MEADOW RANCH II & III

GRADING & EROSION CONTROL PLAN COVER SHEET

C1.12 PROJECT 61209
MVE DRAWING GEC-ED

C1.10
SHEET 10 OF 12

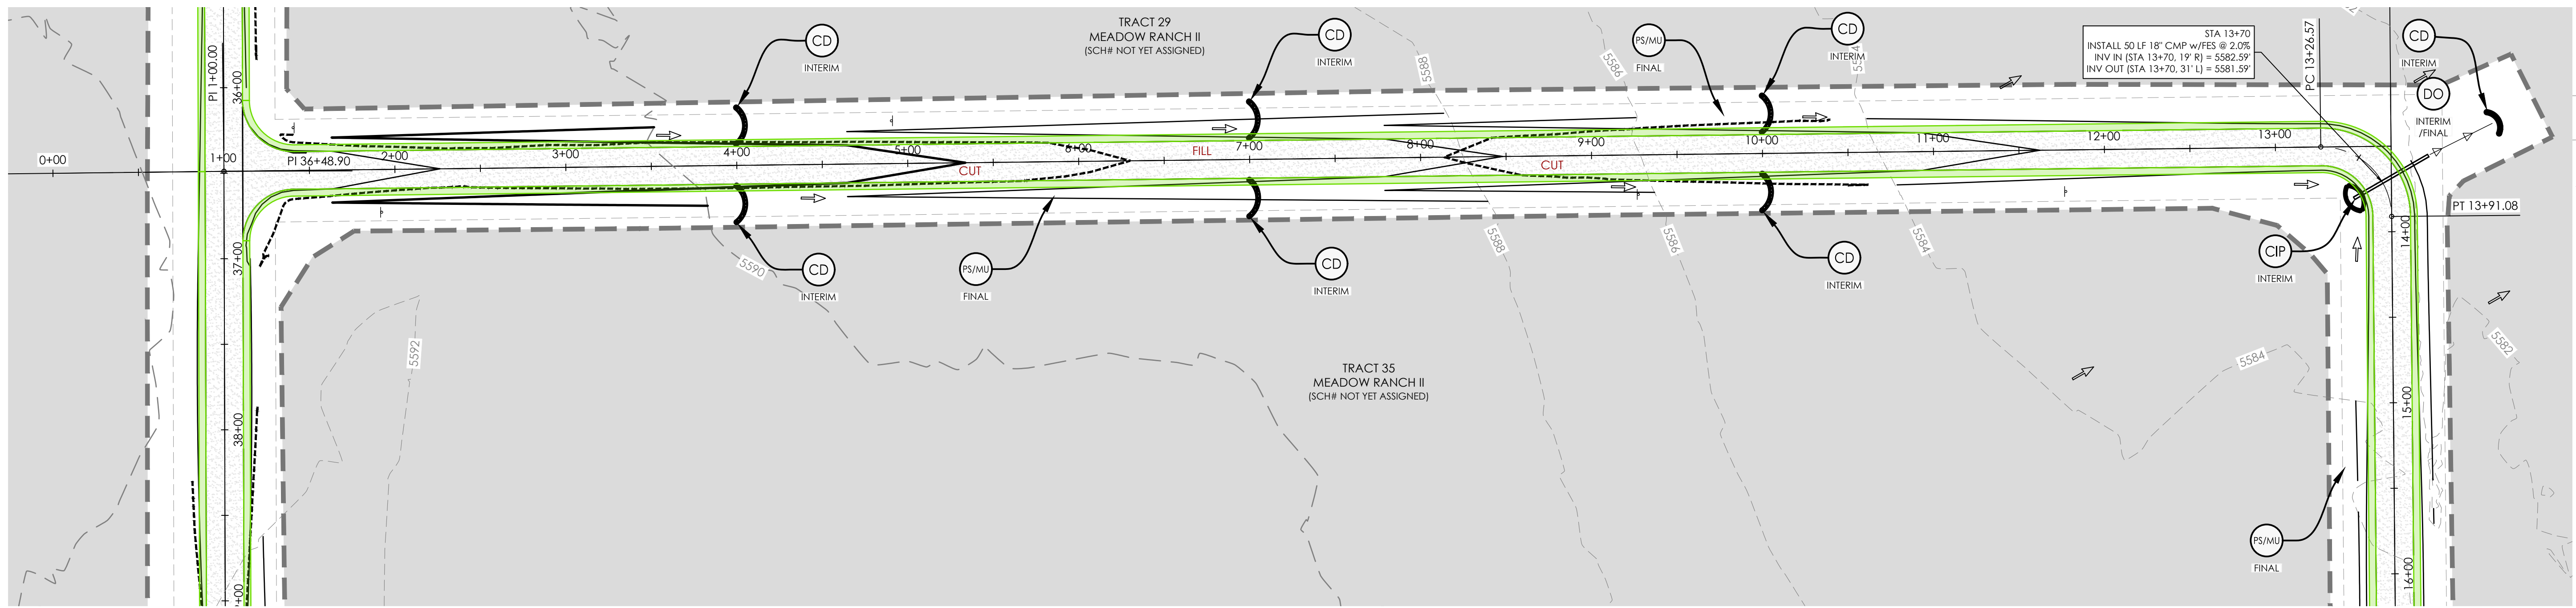
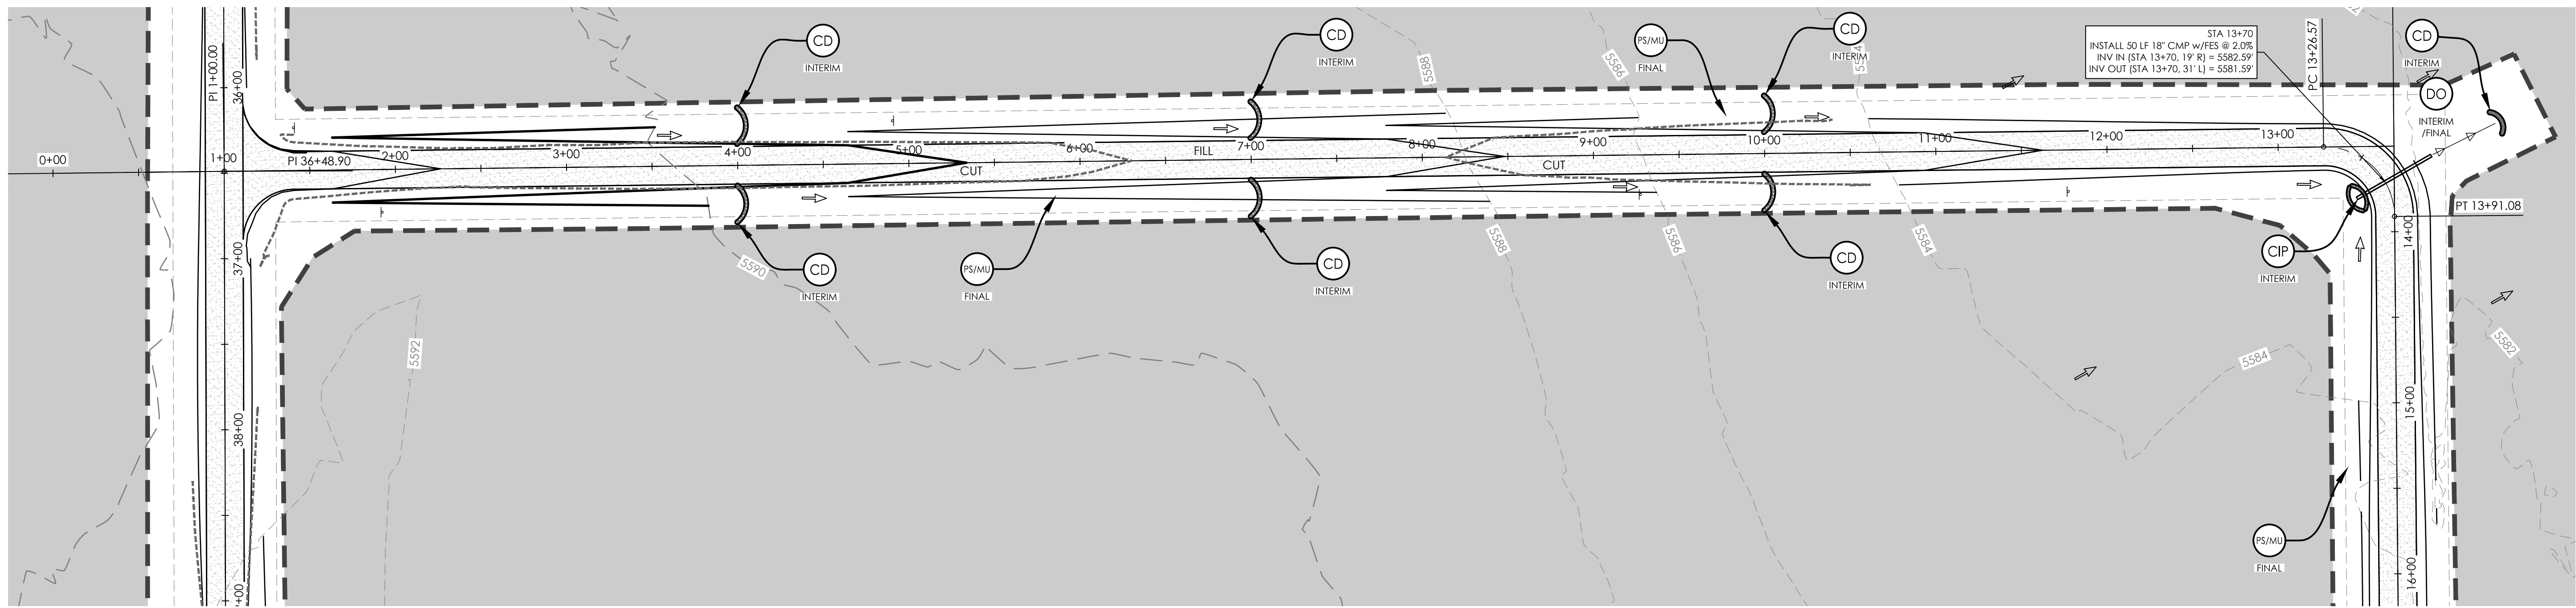
Provide detail for ditch. Will the concentrated ditch flow create erosion downstream? What are velocities? Typical Comment.
